# GOVERNMENT ARCHITECT NEW SOUTH WALES

PROJECT: Wilkinson House SCEGGS  
RE: SDRP SESSION 82 – 4<sup>th</sup> August 2021 (1<sup>st</sup> SDRP)

VISUAL IMPACT - FORBES STREET

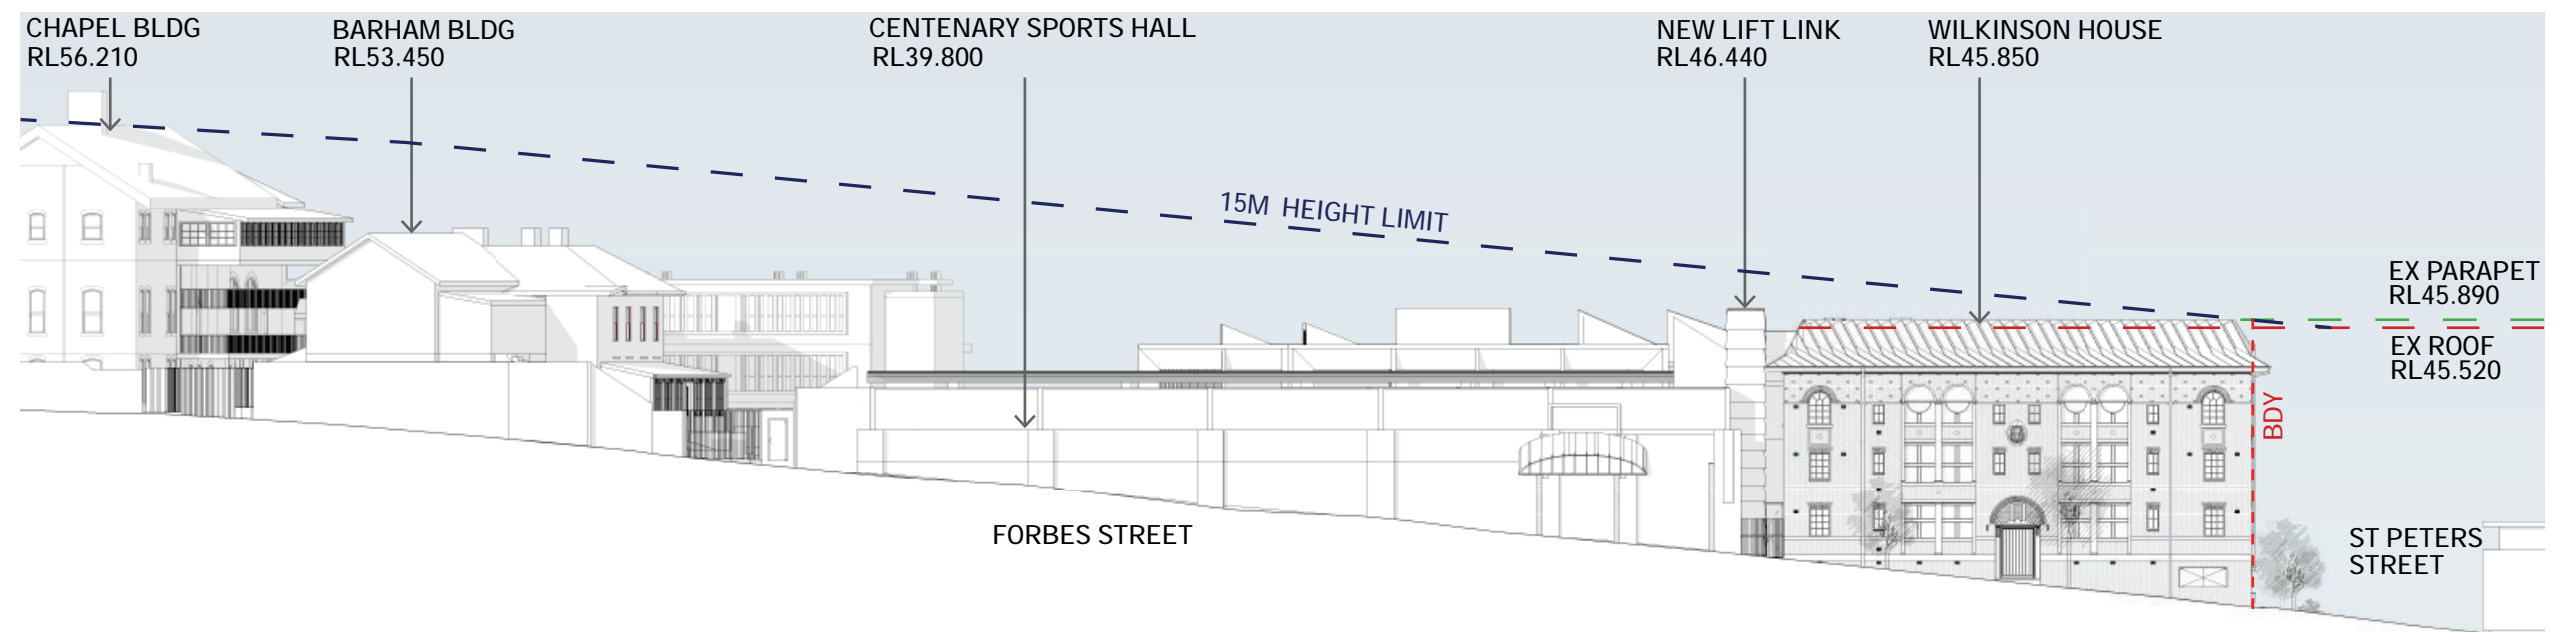
- 3. The proposed height increase, changes to the roof profile and new lift extension is initially supported subject to further design development.
  - a. Provide further detailed street studies illustrating how the modifications and additions to the building sit within the heritage streetscape.

INFILL STEEL WINDOWS

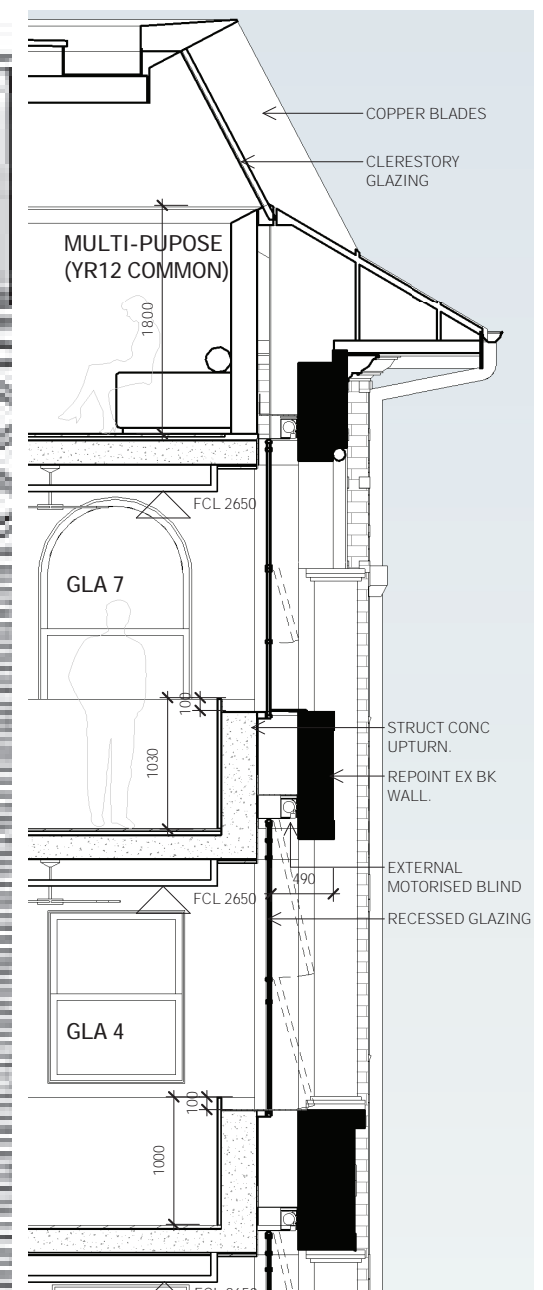
- 4. There is a clear language and rhythm across the facades of solid, voids, shadow and depth which contribute to the heritage character along the streetscape, of which the balconies play a key role. The balcony infill proposed results in the sense of the balconies along the street being lost:

- a. Increase the recess depth of the balcony infill glazing line to a depth that maintains a strong sense of the balconies, including the void and shadow qualities of those spaces.

- b. Provide adequate depth to enable sufficient solar protection to the internal spaces and avoid the introduction of other shading elements.
  - c. Consider full height sliding doors to the balcony glazing to maximise the façade openings, allowing the balconies to be in keeping with their original purpose and provide natural ventilation to the learning spaces.

- d. The glazing design is at early stages and needs further development. Provide detail studies demonstrating the development and refinement of the glazing design and quality of the detailing around the balcony openings.

1 LEVEL 3 ROOFTOP PLANTER  
Scale: 1:20

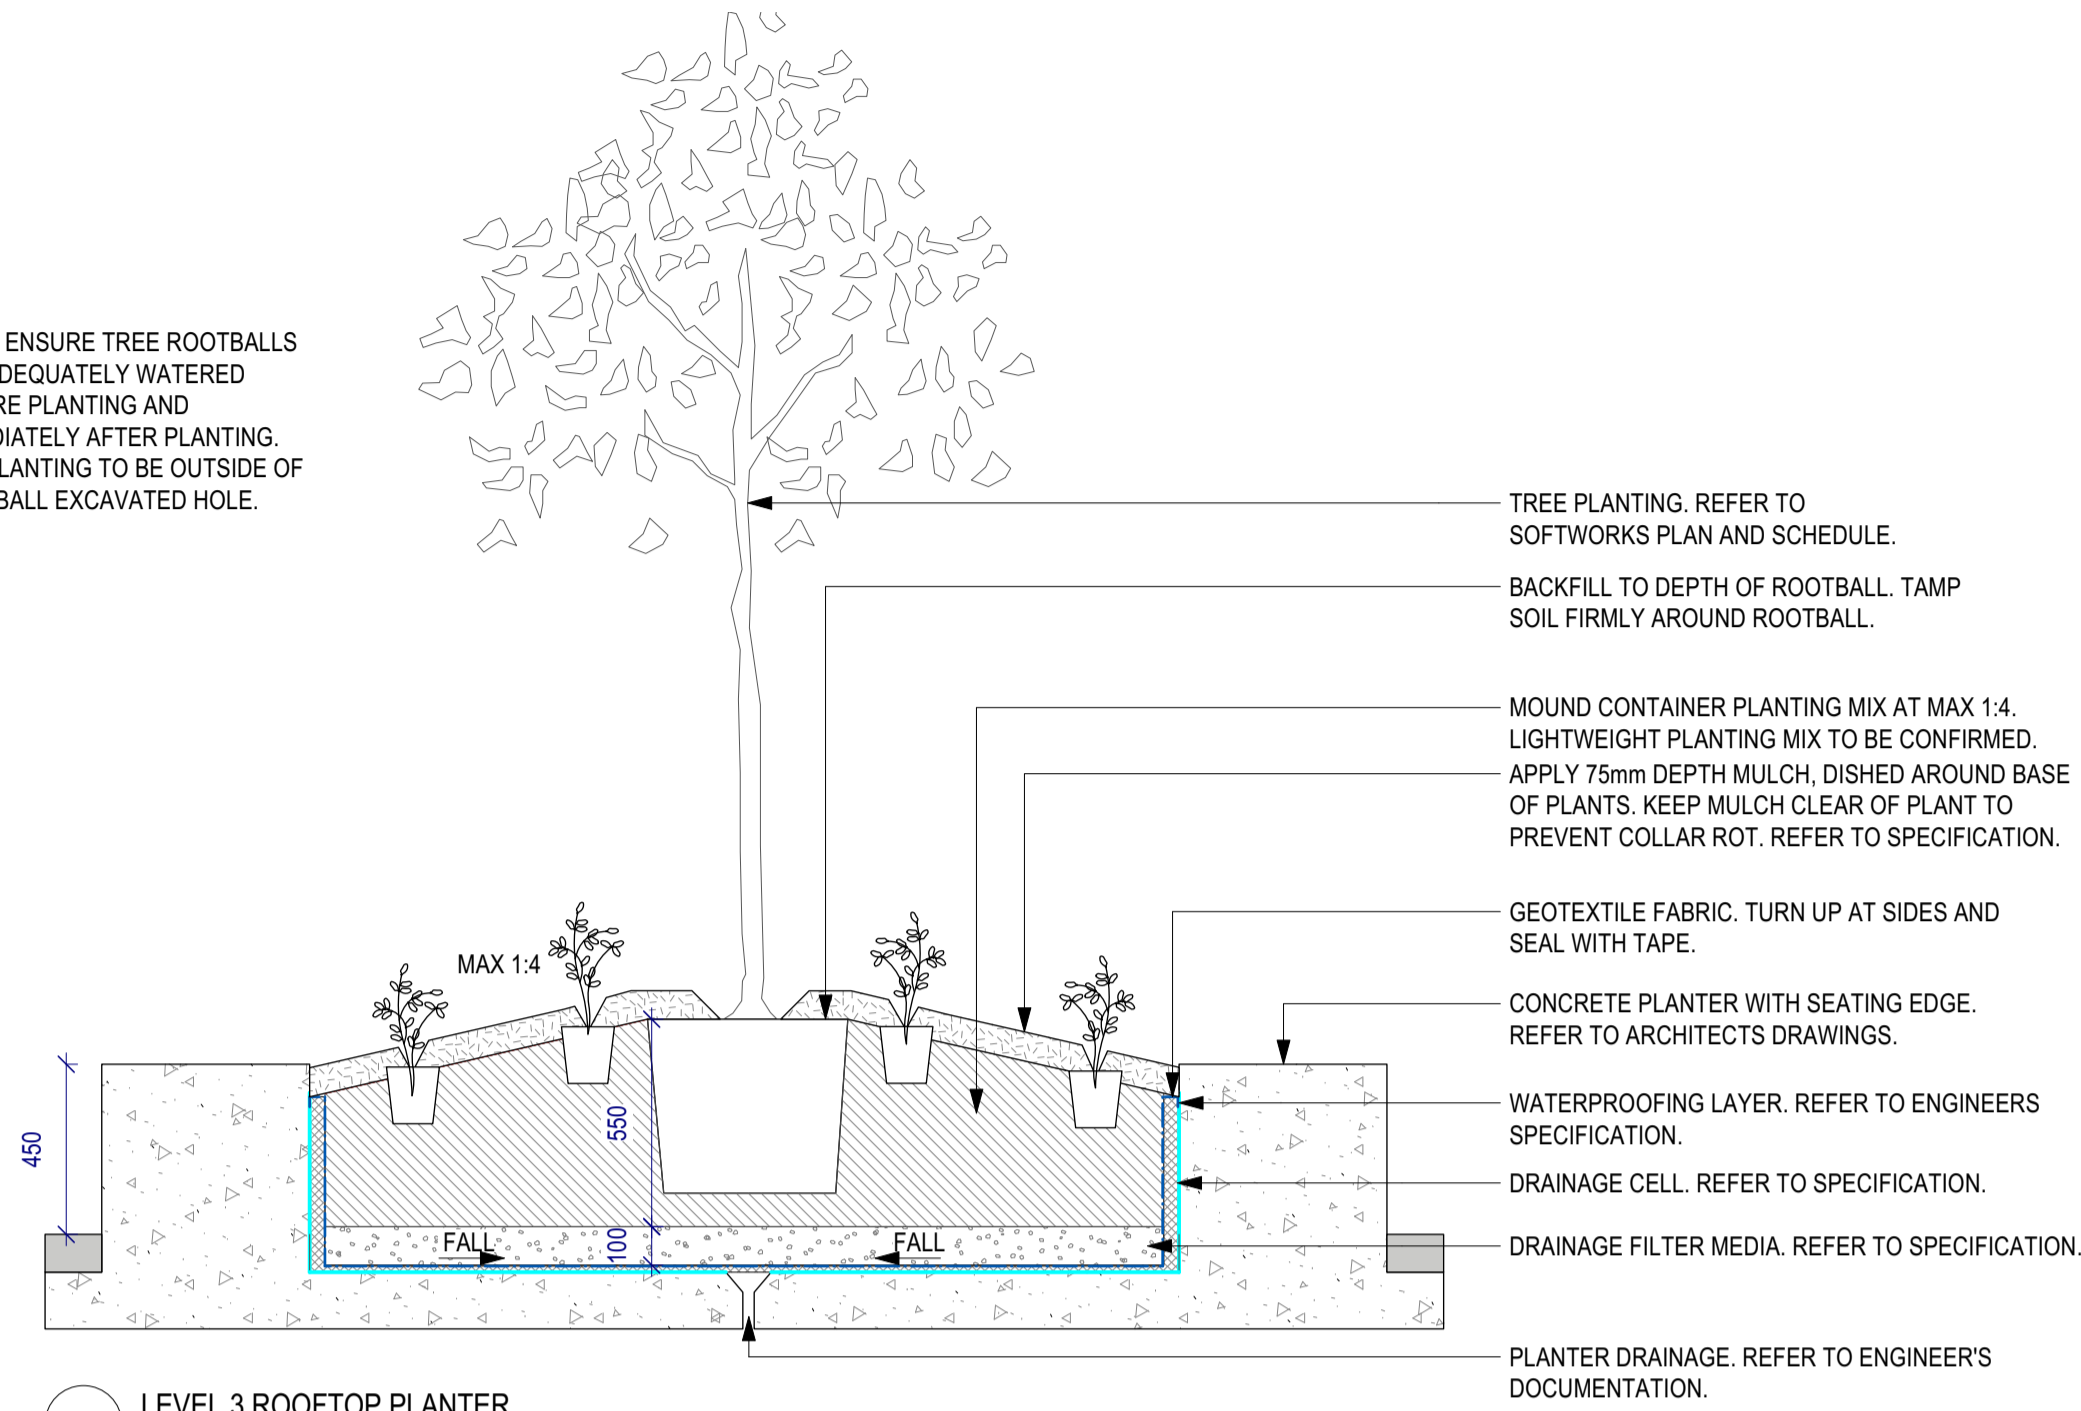
- d. Seek opportunities to incorporate Indigenous stories and approaches to learning as a living culture into the school.
2. The oculus in the roof, rooftop tree and terrace are supported however the proportion, scale and species of tree will influence the success of the space.

- a. Provide spatial studies to illustrate the space is of appropriate scale and design for the intended use.
  - b. Investigate appropriate tree species that will be able to thrive in the rooftop location and grow to a suitable scale for the space. Consider opportunities to reference the pre-colonial landscape of the site.
